A47 North Tuddenham to Easton

Scheme Number: TR010038

9.4 Draft Development Consent Order - Schedule of Drafting Changes for Deadline 3

**DRAFT DEVELOPMENT CONSENT ORDER:
SCHEDULE OF DRAFTING CHANGES FOR DEADLINE 3**

DRAWING TITLE  
**RIGHTS OF WAY AND ACCESS PLANS REGULATION 5(2)(k) AND 5(2)(o) SHEET 6 OF 23**

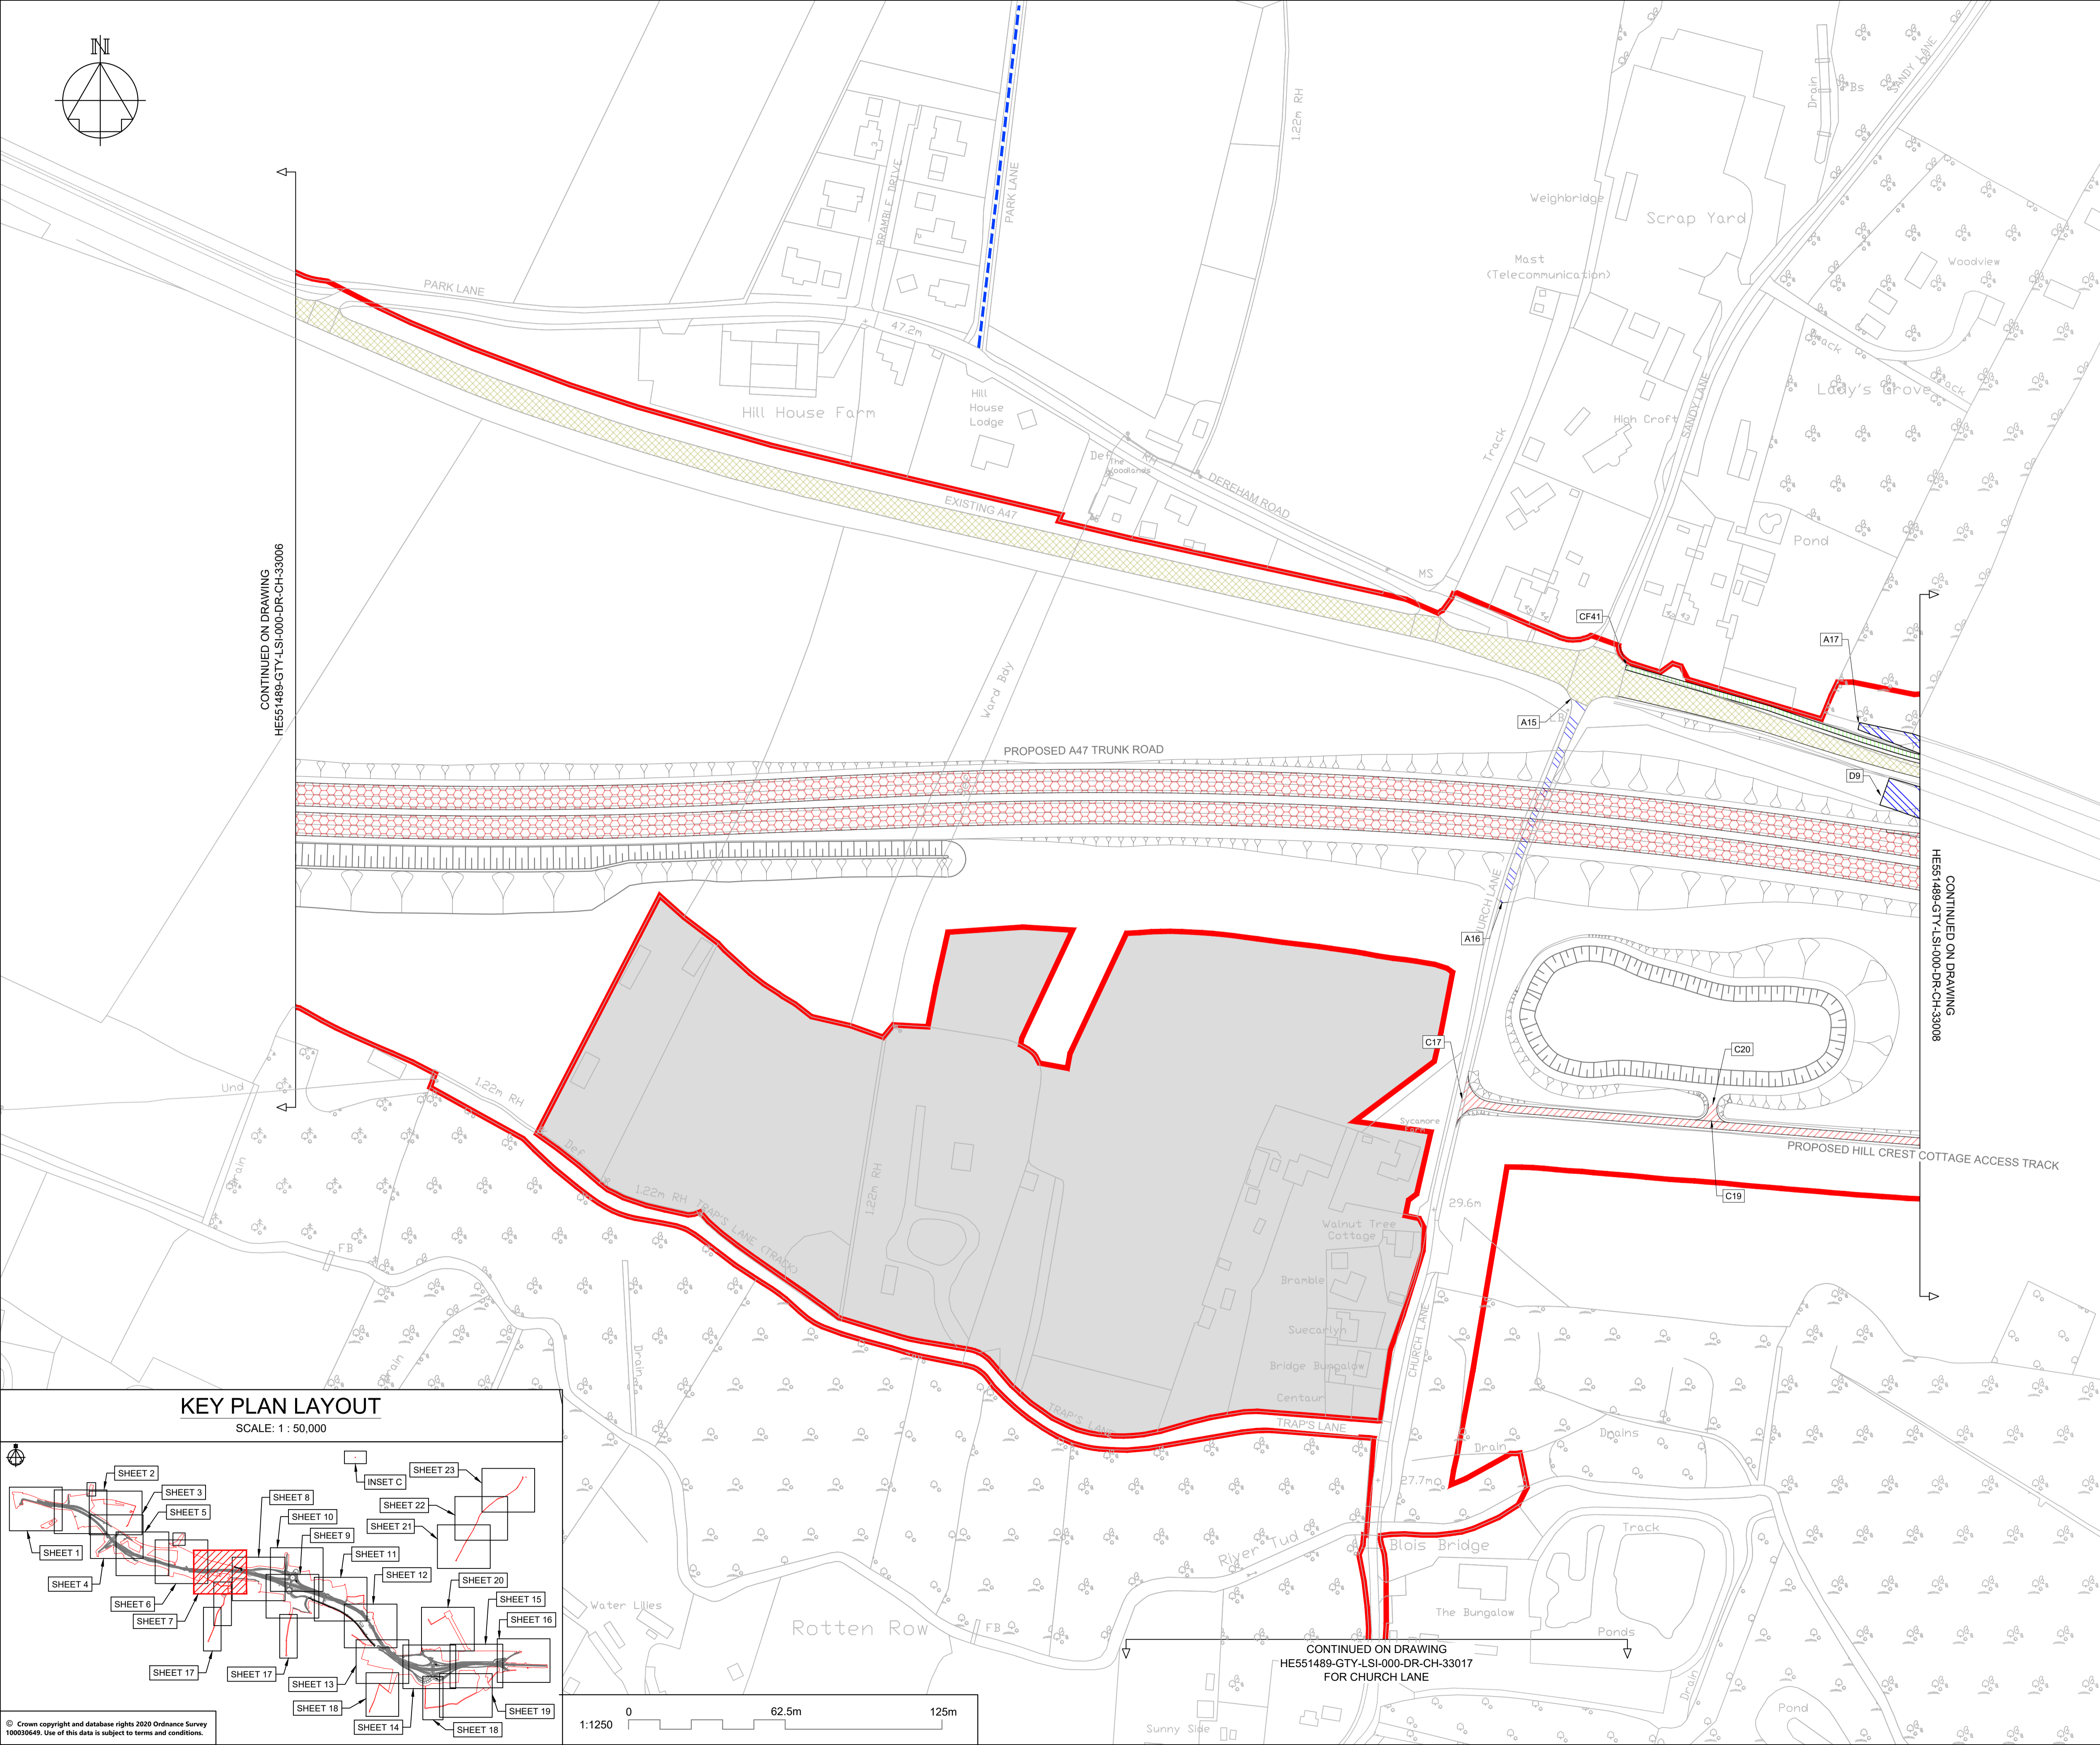
Schedule 4, Part 1, The rights of way and access plans – sheet 6	The words "A10" has been deleted and replaced with "A11" The word "public" has been capitalised and the words "southerly direction for 70metres and then a" has been deleted. The number "116" has been deleted and replaced with "95".	The reference to A10 has been corrected to A11 and the distances have been changed as a result of amendments to the base map as stated in the Applicant's response to RR-037.58	N/A	N/A
Schedule 4, Part 2, The rights of way and access plans – sheet 2	The words "and cycle track connection" has been inserted.	The description of the highway has been amended for accuracy.	N/A	N/A
Schedule 4, Part 2, The rights of way and access plans – sheet 6	In the third column, the number "21" has been deleted and replaced with "54" In the fourth column, the number "24" has been deleted and replaced with "55"	The distances have been updated as a result of amendments to the base map as stated in the Applicant's response to RR-037.58	N/A	N/A

Article/Schedule	Change	Reason for change	Precedent used	Consequential changes
Schedule 4, Part 2, The rights of way and access plans – sheet 6	In the third column, the number "19" has been deleted and replaced with "16"	The distances have been updated as a result of amendments to the base map as stated in the Applicant's response to RR-037.58	N/A	N/A
Schedule 4, Part 2, The rights of way and access plans – sheet 10	In the third column, the number "141" has been deleted and replaced with "467"	The distances have been changed as a result of amendments to the base map as stated in the Applicant's response to RR-037.58	N/A	N/A
Schedule 4, Part 3, The rights of way and access plans – sheet 16	In the fourth column, the words "79 metres west of" have been deleted and replaced with "at". The number "14" has been deleted and replaced with "89"	The description of the private access has been updated so that it is clear the access is closed from Ringland Lane	N/A	N/A

Schedule 4, Part 4, The rights of way and access plans – sheet 6	A new row has been inserted. In the first column, the words "Norfolk County Council Hockering Parish" have been inserted. In the second column, the words "Reference B11 to B12 Private access road to Newgate House" has been inserted. In the third column, the words "Reference B11 to B12 A point B11 extending south towards Newgate House to point B12, a distance of 32 metres" have been inserted.	This is a private road, not a public highway, so has been moved from Part 1 to Part 4 of Schedule 3.	N/A	N/A
Schedule 9, Part 4	The Protective Provisions for the protection of Anglian Water Services Limited have been updated.	The updated drafting reflects the latest draft of protective provisions in circulation.	N/A	N/A

DRAWING TITLE  
**RIGHTS OF WAY AND ACCESS PLANS  
REGULATION 5(2)(k) AND 5(2)(o)  
SHEET 7 OF 23**

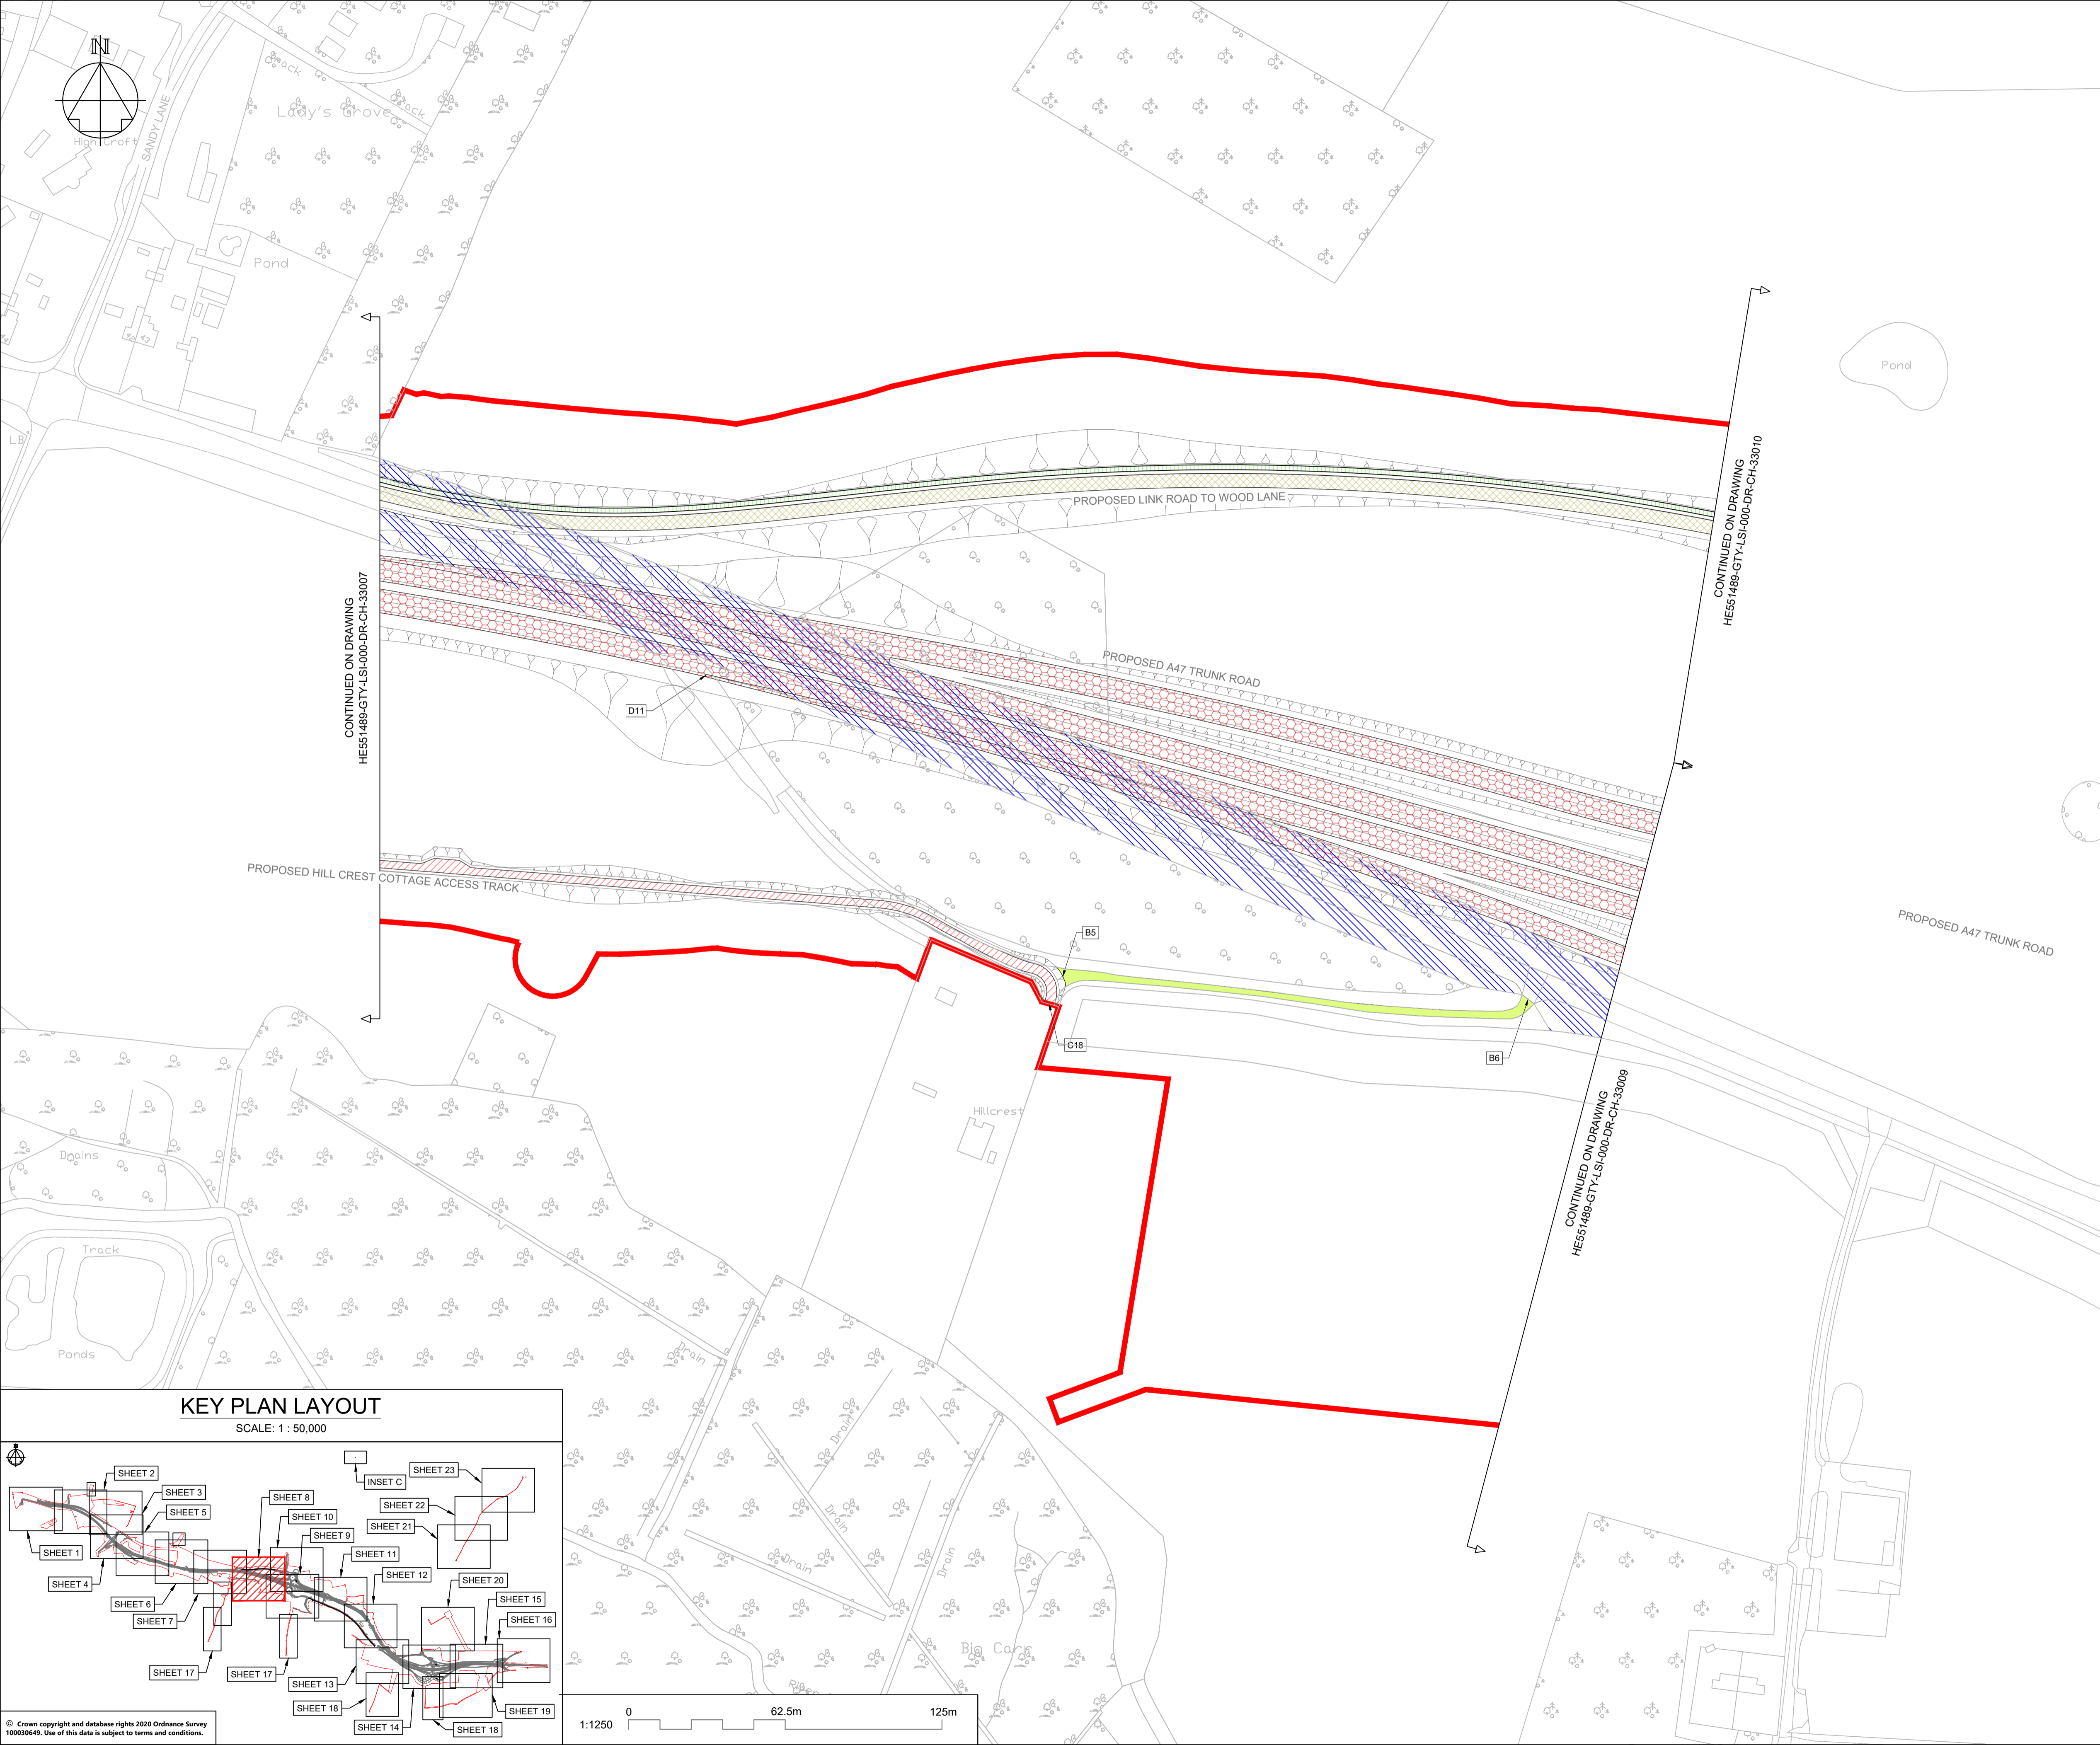
Schedule 3, 'Classifications of Roads', Part 6, The rights of way and access plans – sheet 7,	The number "813" has been deleted and replaced with "844".	Following a review of the cycle track provision, the cycle track along the northern verge of the existing A47 has been extended to replace CF39 to CF40.	N/A	N/A
